# CITY OF ALBUQUERQUE

PLANNING DEPARTMENT – Development Review Services

July 9, 2015

**RE: Los Diamantes Subdivision  
Drainage Report, and Grading and Drainage Plan  
Engineer's Stamp Date 6-5-2015 (File: N09D013)**

Drawing file: june 5 2015 submittal / 14031 Grading Plan Revised 2015-06-05.pdf

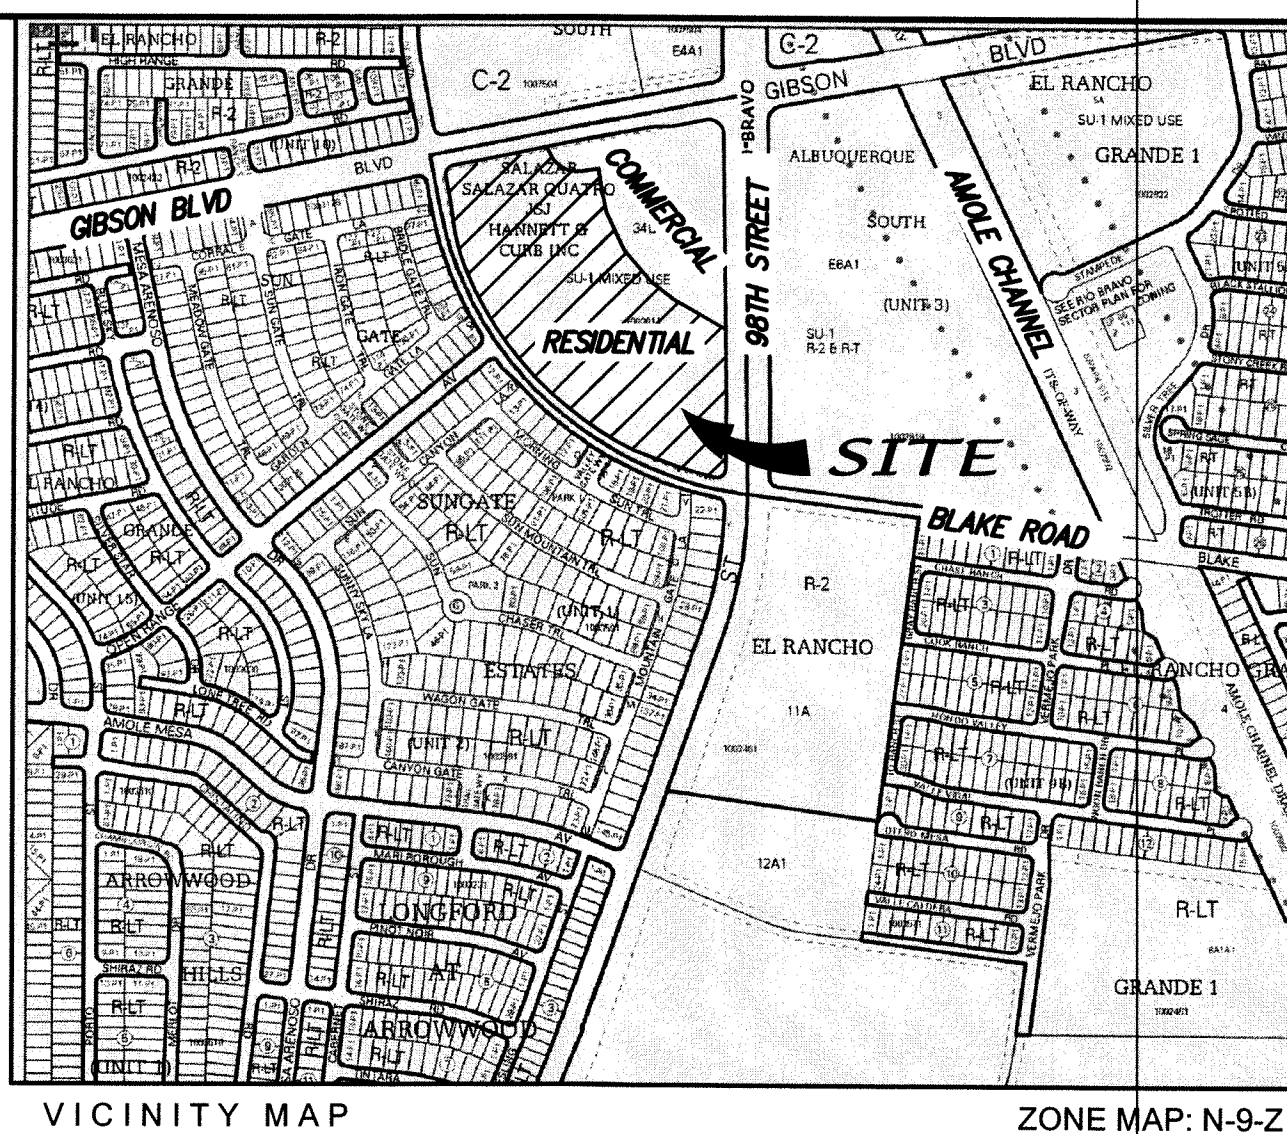
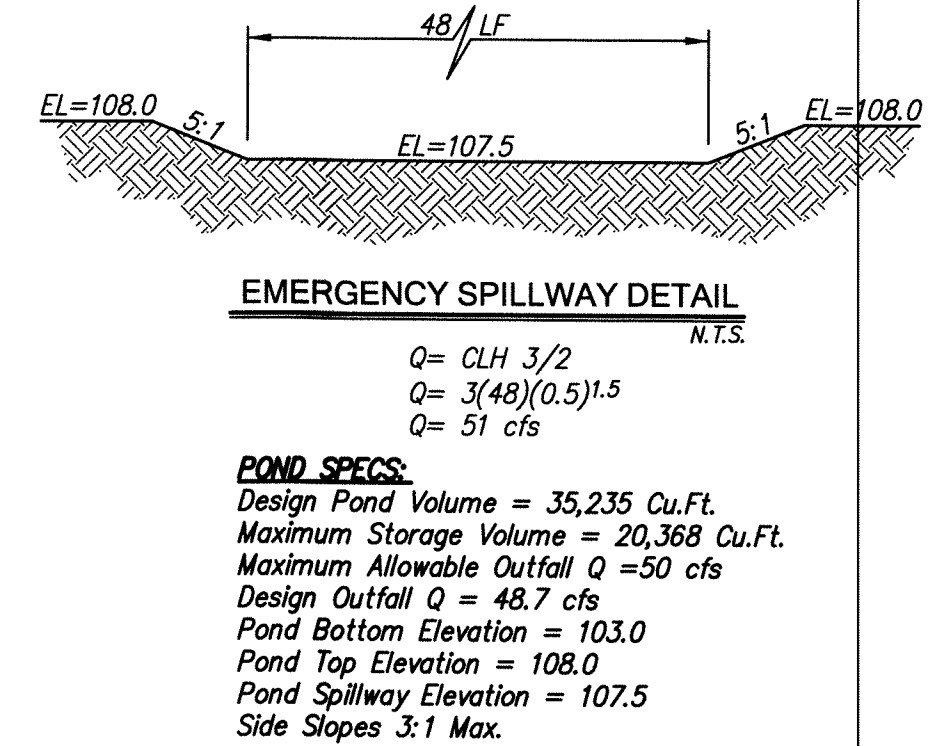
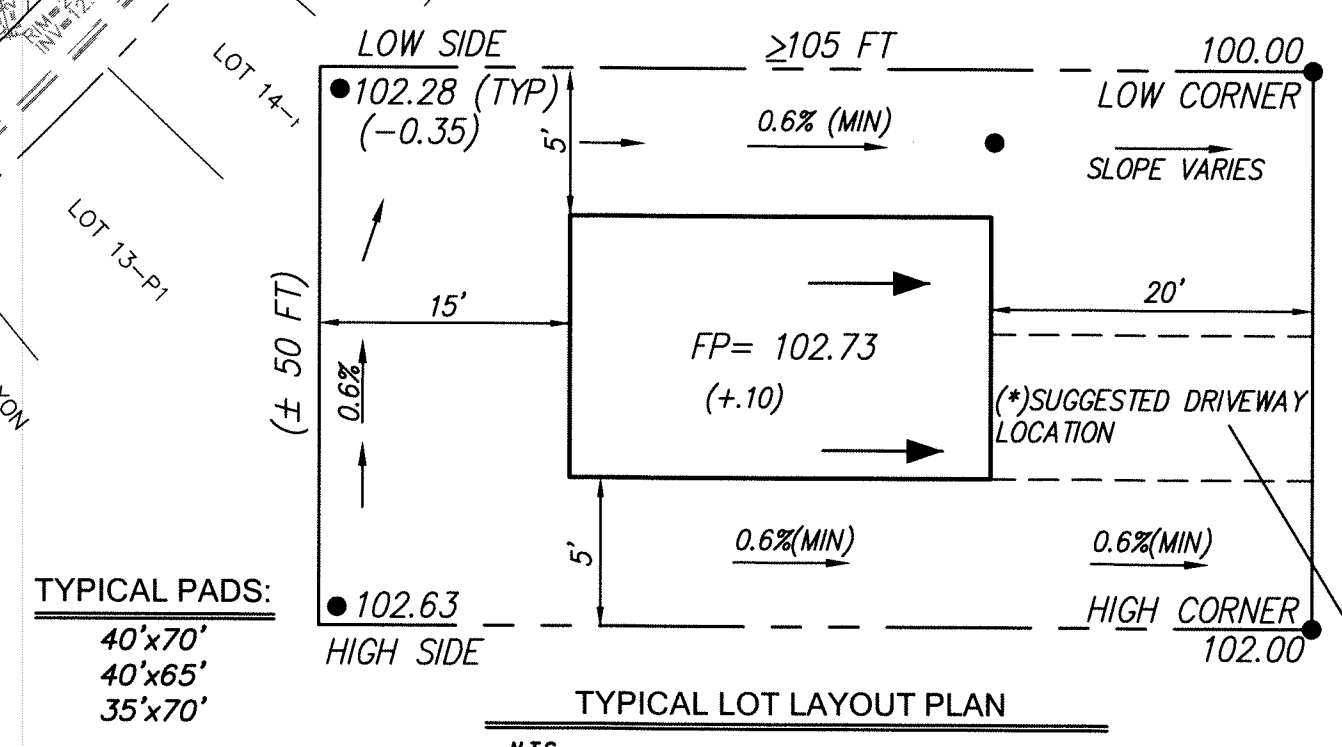
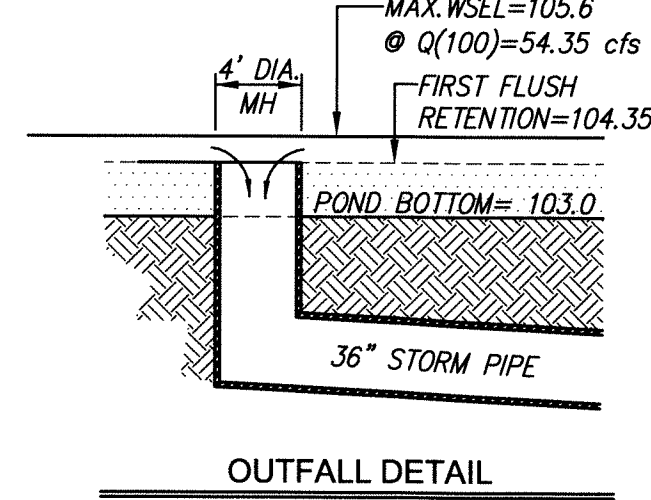
2. Tract A historically discharged to the NW corner of 98<sup>th</sup> St and Blake, and is now proposed to drain to a temporary pond. Per DPM 22-5.I, this pond must be sized as a full retention pond with an emergency overflow leading to 98<sup>th</sup> St. Calculations and pond details need to be included in with this project. Show pond volume and max WSEL. Alternatively, the pond may discharge to the 24" storm drain noted above.

5. The TC/FL elevations along the Curb and Gutter are barely readable – please darken the font. Looking at the elevations shown close to Tract B on Gibson Blvd, the TC is 48.17, FL is 44.5, top of sidewalk is 47.82. Obviously there are errors. Additionally, the passage way into the subdivision is from 47.82 to 46.00 and approximately 34' long, which gives you a slope of 5.35%. Is this ADA acceptable?

INLET GOOD DUST WAY CULDESAC TO POND

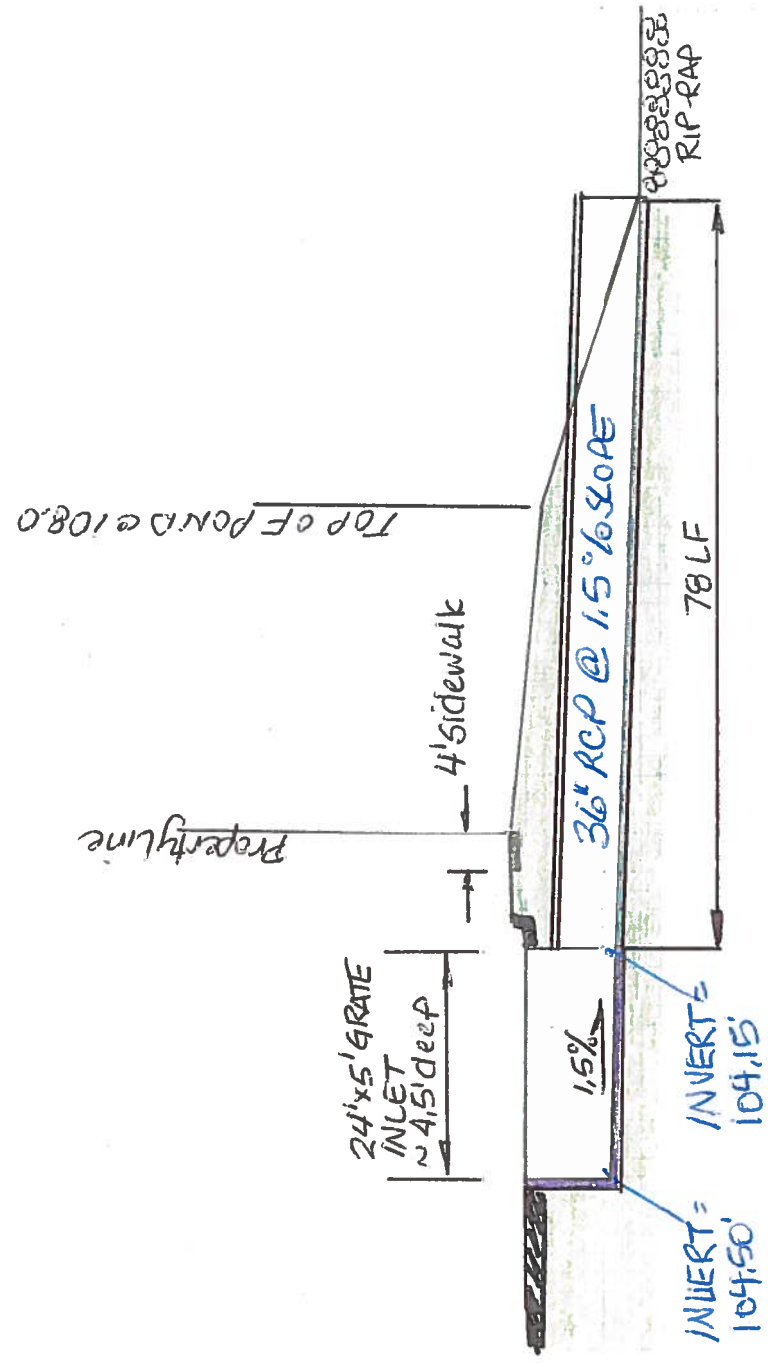
3. According to the City engineer the cattle guard inlet shown is acceptable if a structural detail is provided, and included in the Work Order plan set. Remove city standard details from the report since grated inlet is custom designed.

4. Regarding the Cattle Guard Inlet: Per DPM 22 –D.3(4), Catch basins in sump condition need to be designed for account for system clogging. The DPM lists 2 emergency backup options, but a 3<sup>rd</sup> backup option is that the Cattle Guard can capture 2x the 100-yr event. **Per your email you state that the maintenance road can be used as a spillway into the pond.** This is acceptable, but show that the Max WSEL does not rise above any adjacent structure pad elevations. (1<sup>st</sup> backup option in the DPM) or show that the maintenance road/channel will convey overflows given a 50% clogging factor
